MECKLENBURG COUNTY  
Park and Recreation Department

MEMORANDUM

**DATE:** February 22, 2024

**RE:** Rezoning Petition #2024-011  
PID# 02946195A

Project No.	Drawing No.
5783	
DWG File Name:	
5783 - Rezoning Site Plan	C1.02

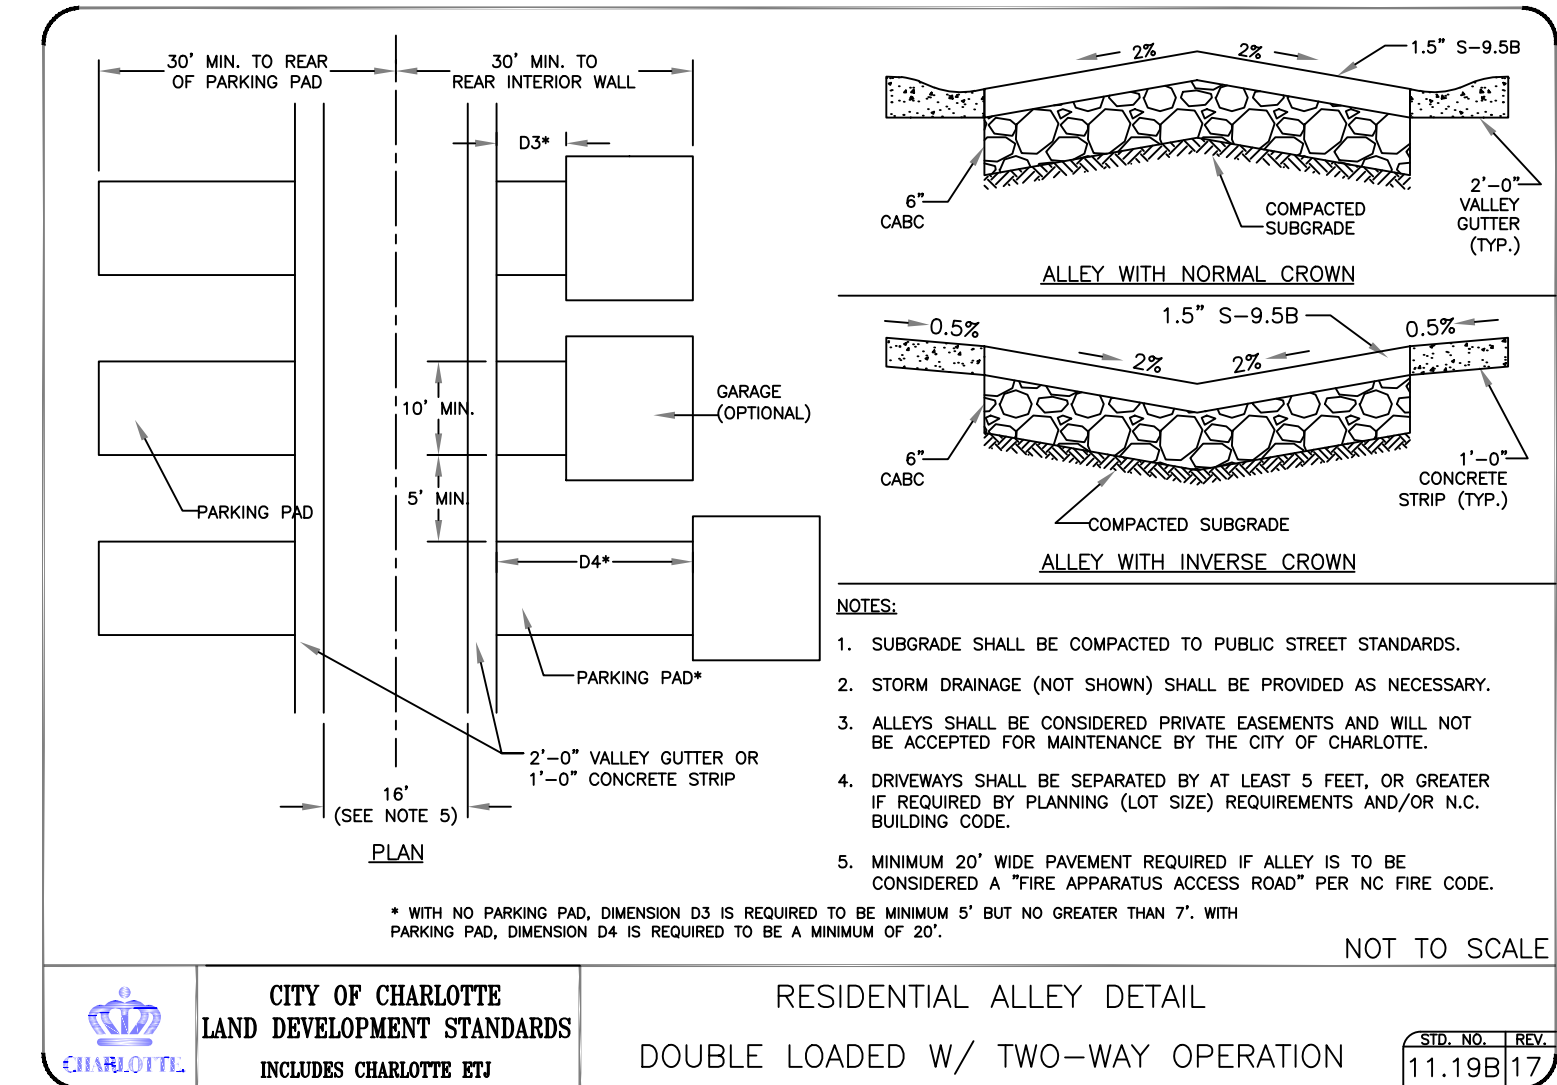
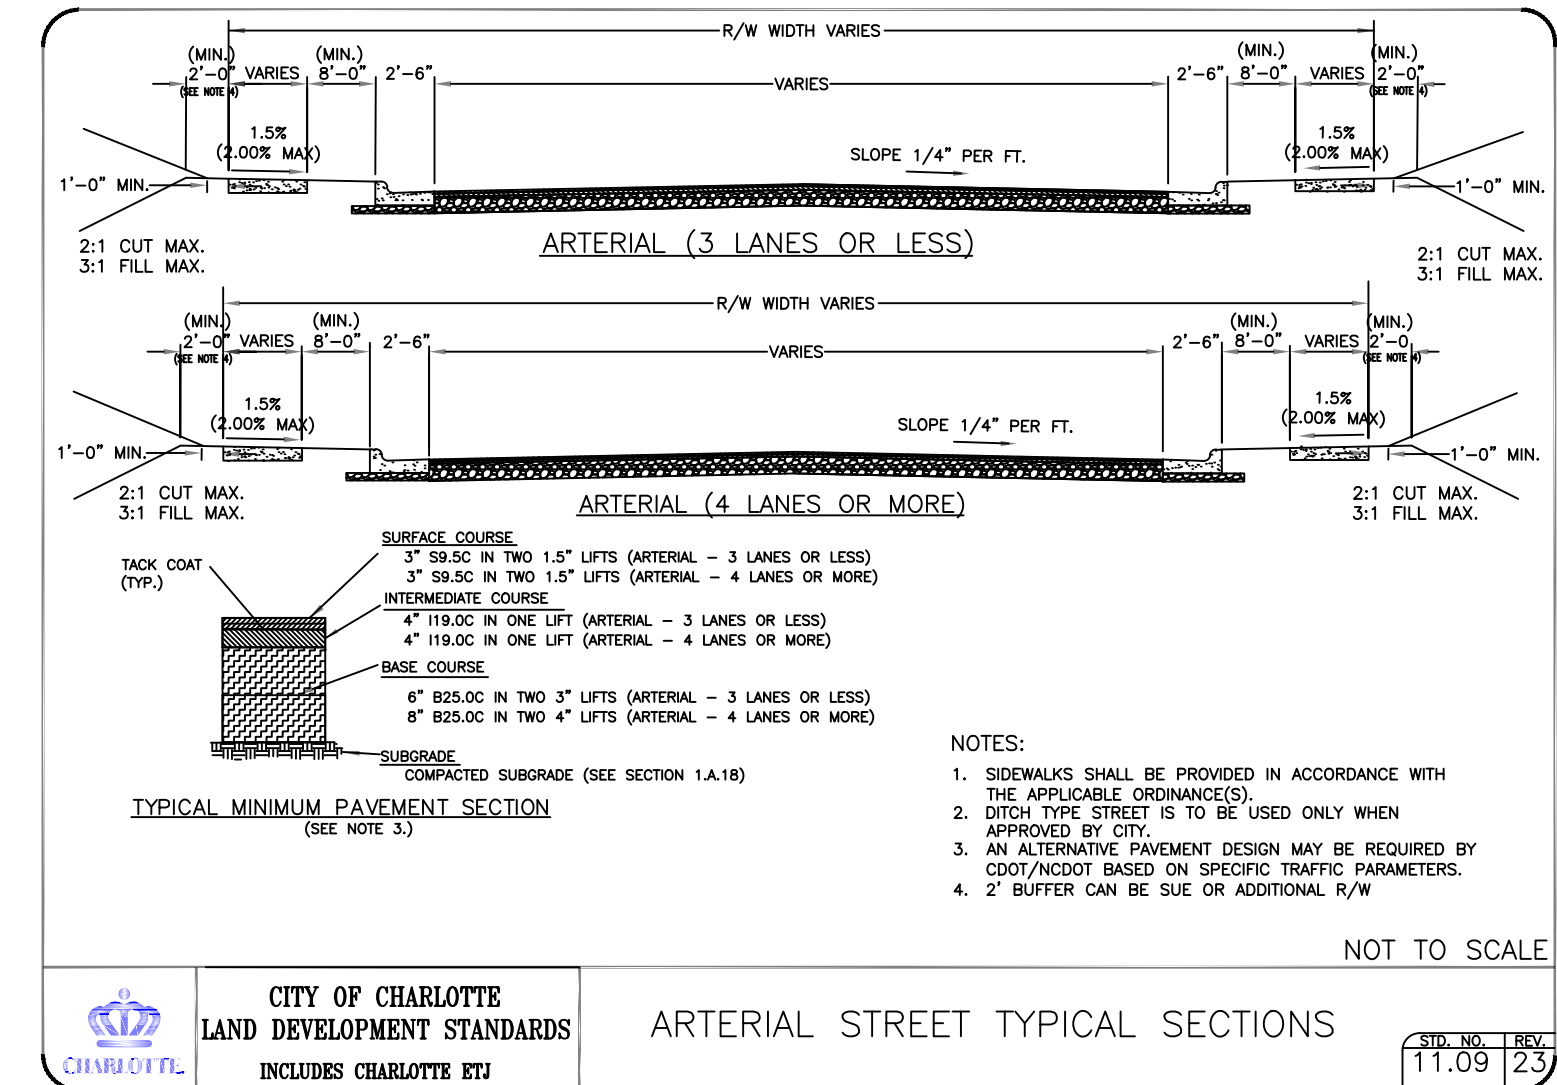
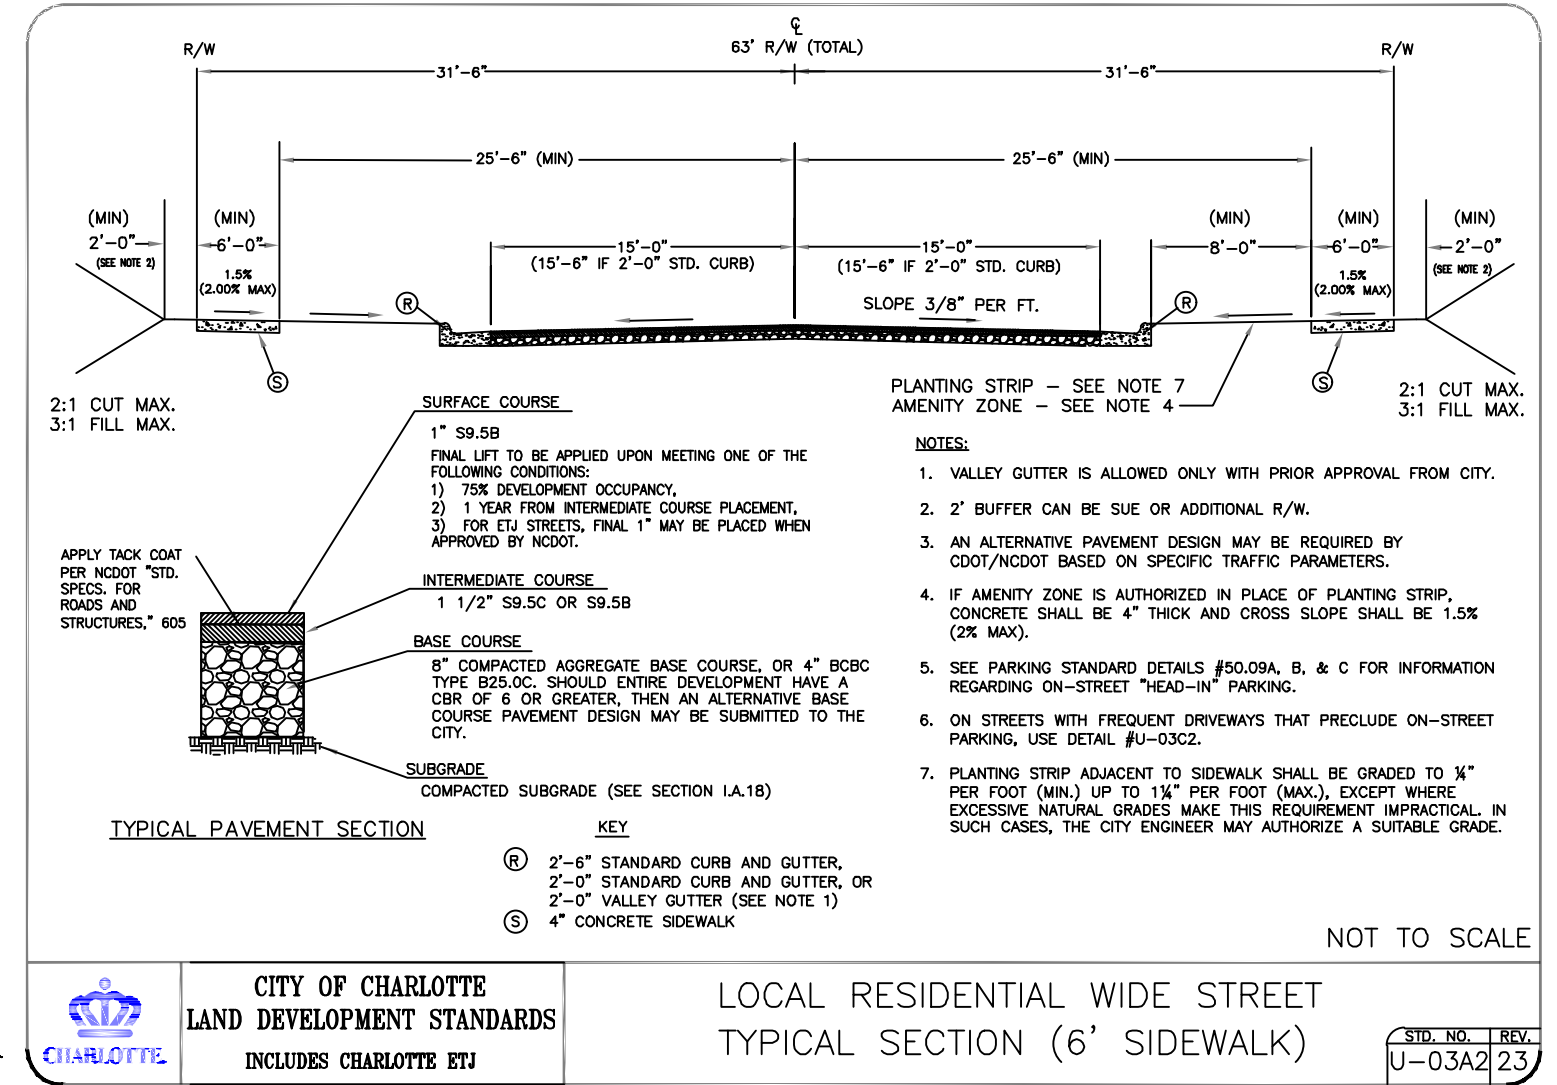
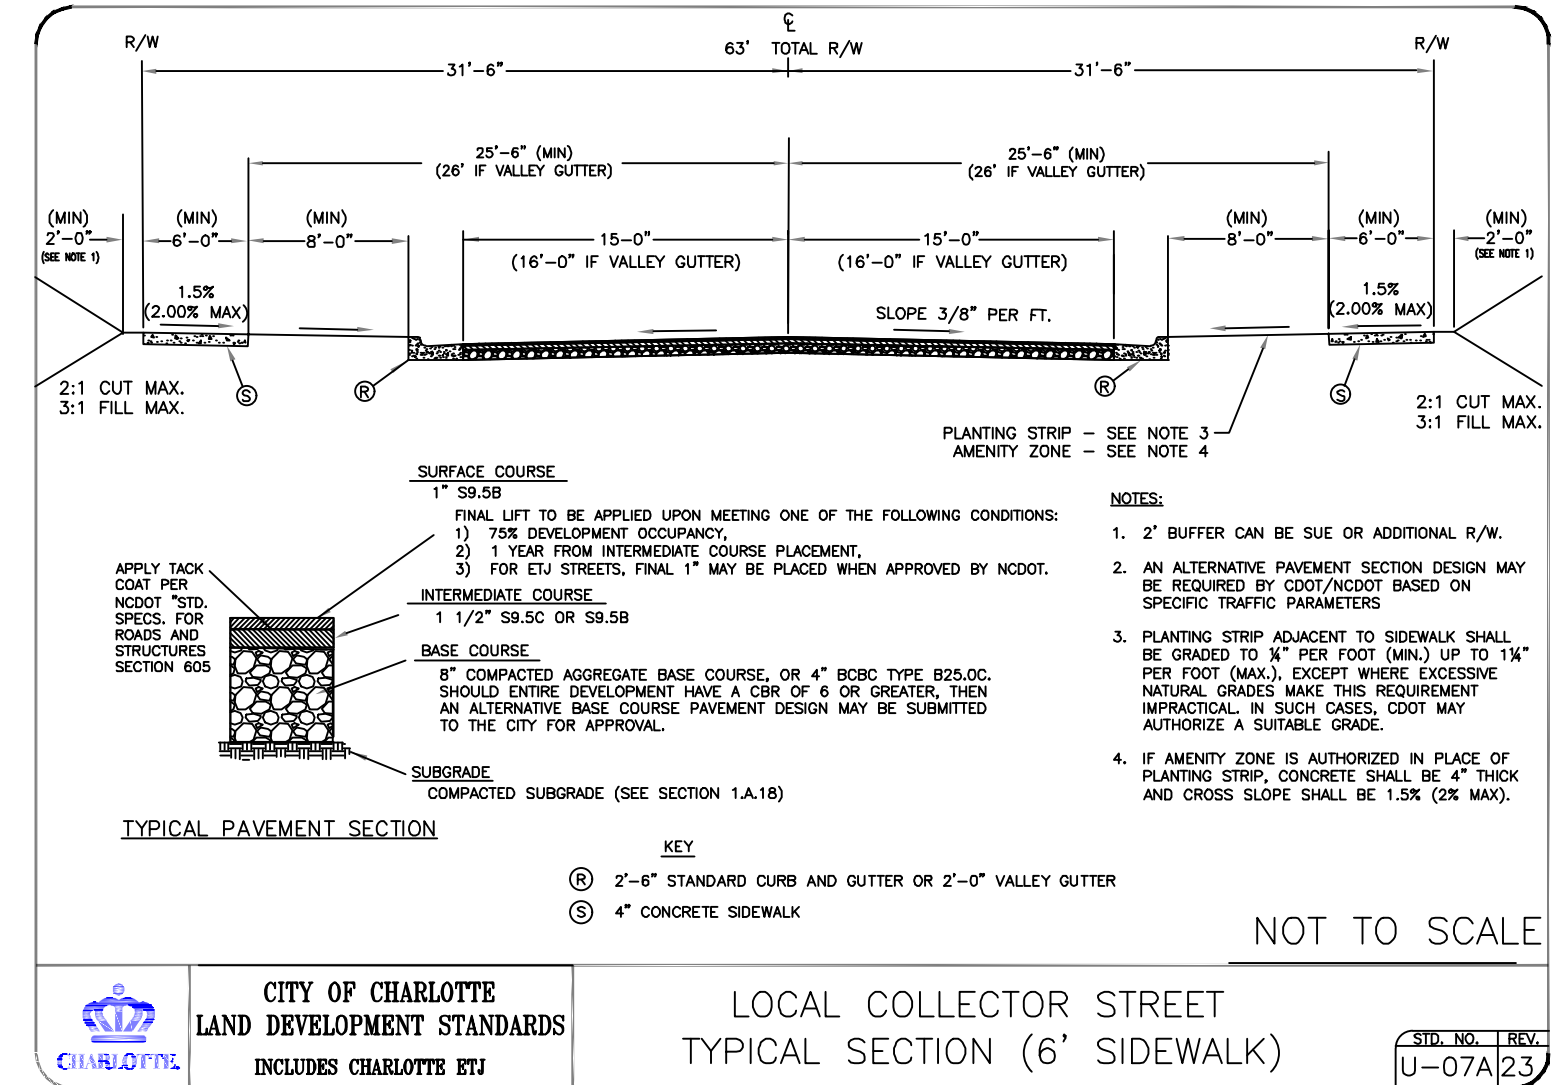
This parcel is a proposed urban trail on the Mecklenburg County Greenway Master Plan. Please provide pedestrian and bicycle accommodations along the frontage of Johnston Oehler Rd.
